Recommendation Report for Planning Permission for Works or Extension to a Dwelling

REF NO: AB/129/19/HH

LOCATION: 75 Maltravers Street
Arundel
BN18 9BQ

PROPOSAL: Single storey side extensions and entrance porch. (This application may affect the setting of a Listed Building. This application affects the character and appearance of the Arundel Conservation Area).

Proposed Extension and Alterations
at Owls Hoot, Arundel
for Mr R Dowson & Ms S Harnett
Drawing P02 October 2019 Scale 1:100 @ A3
Planning Drawing - Ground Floor & Roof Plan & Elevations

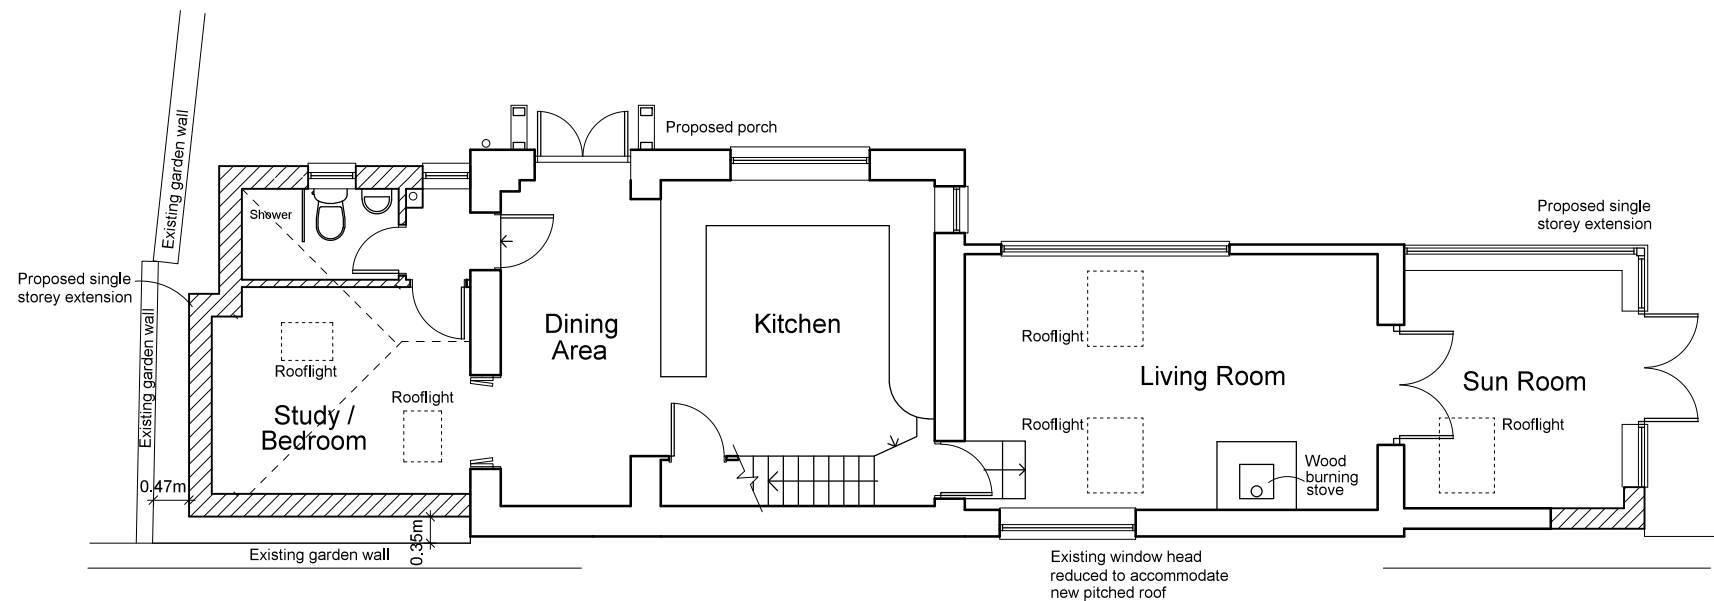
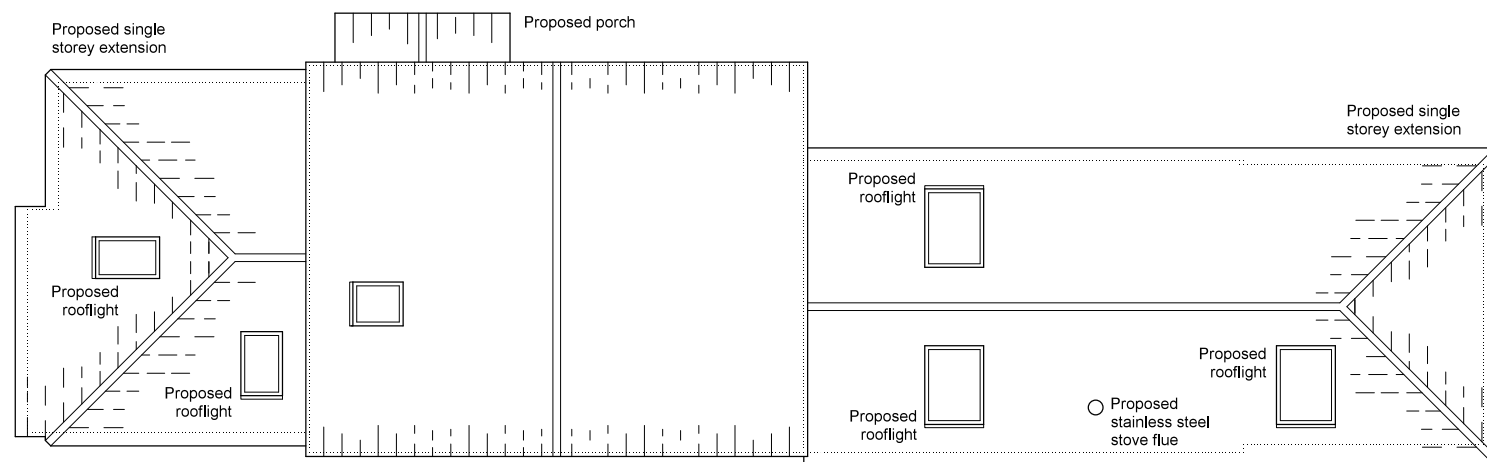
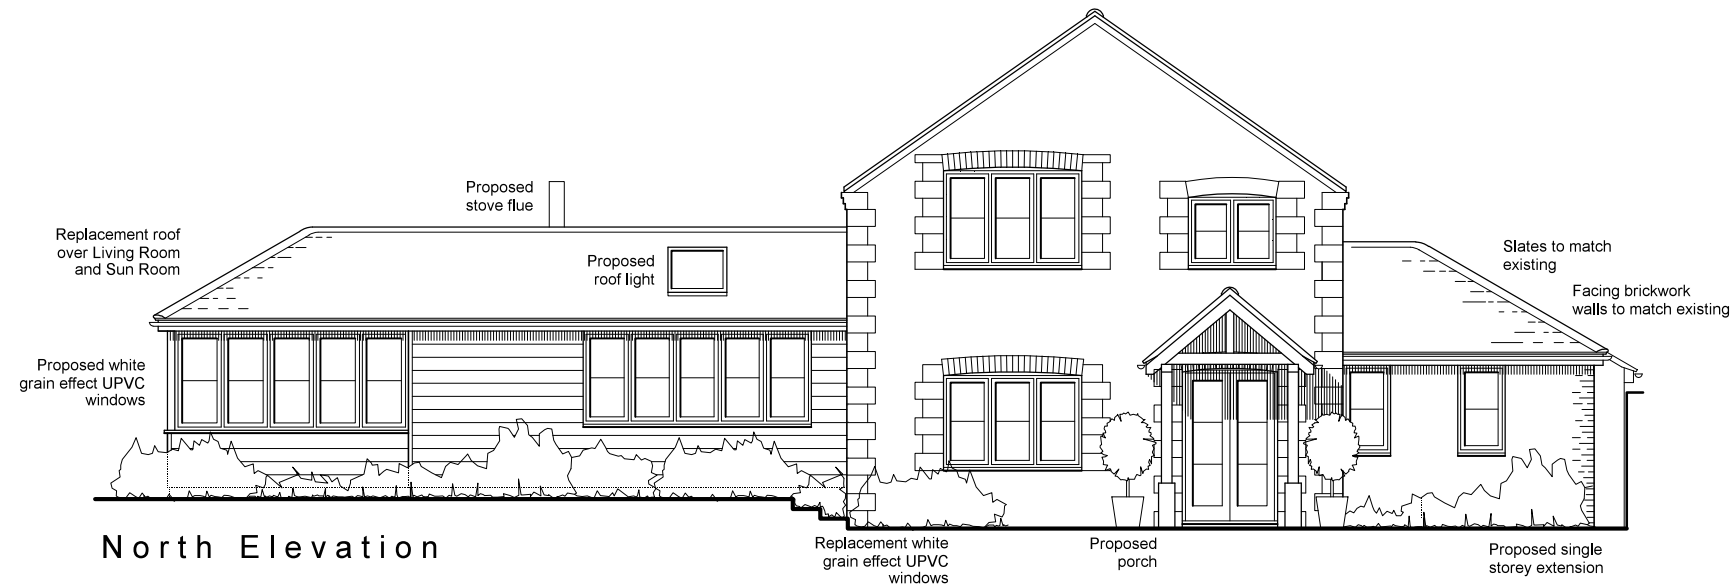
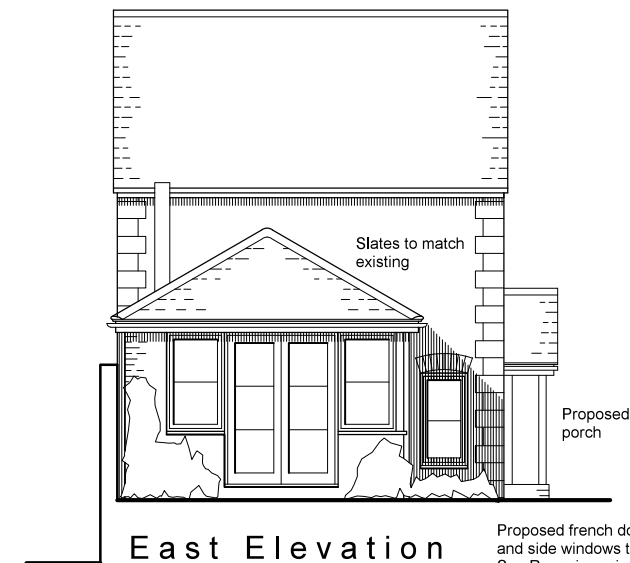
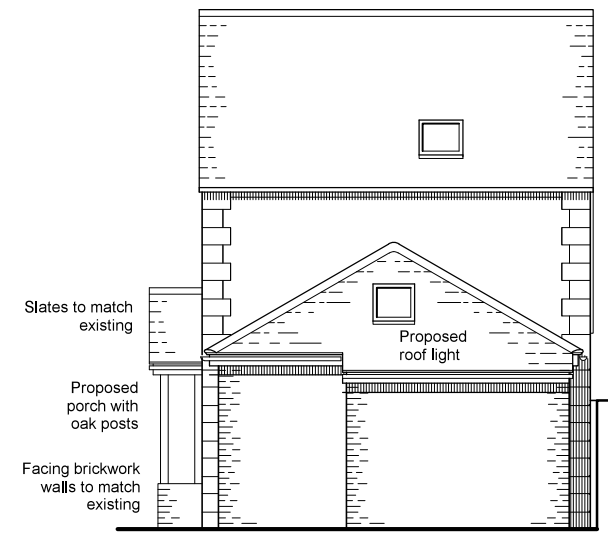
Conservation Officer - No objection.
- The Conservation Officer raises no issue with the physical elements of the proposed development.
- The Conservation Officer states that the proposed materials are problematic, and would result in some harm to the building, and the surrounding conservation area.

- The Committee do object to the proposed materials, and believe that these should be required to be submitted via planning condition.

The proposed development is considered to be acceptable on all grounds except the proposed materials, therefore, an agreement was reached with the agent allowing the plans condition to specifically not approve the reference to the materials. Therefore, the application will be approved subject to the following conditions.

- 2 The development hereby approved shall be carried out in accordance with the following approved plans, without reference to the proposed materials, which are subject to Condition 3:

- 3 No development above damp proof course (DPC) level shall take place unless and until a schedule of materials and finishes to be used for external walls, roofs and joinery of the proposed development have been submitted to and approved by the Local Planning Authority and the materials so approved shall be used in the construction of the building/extension.
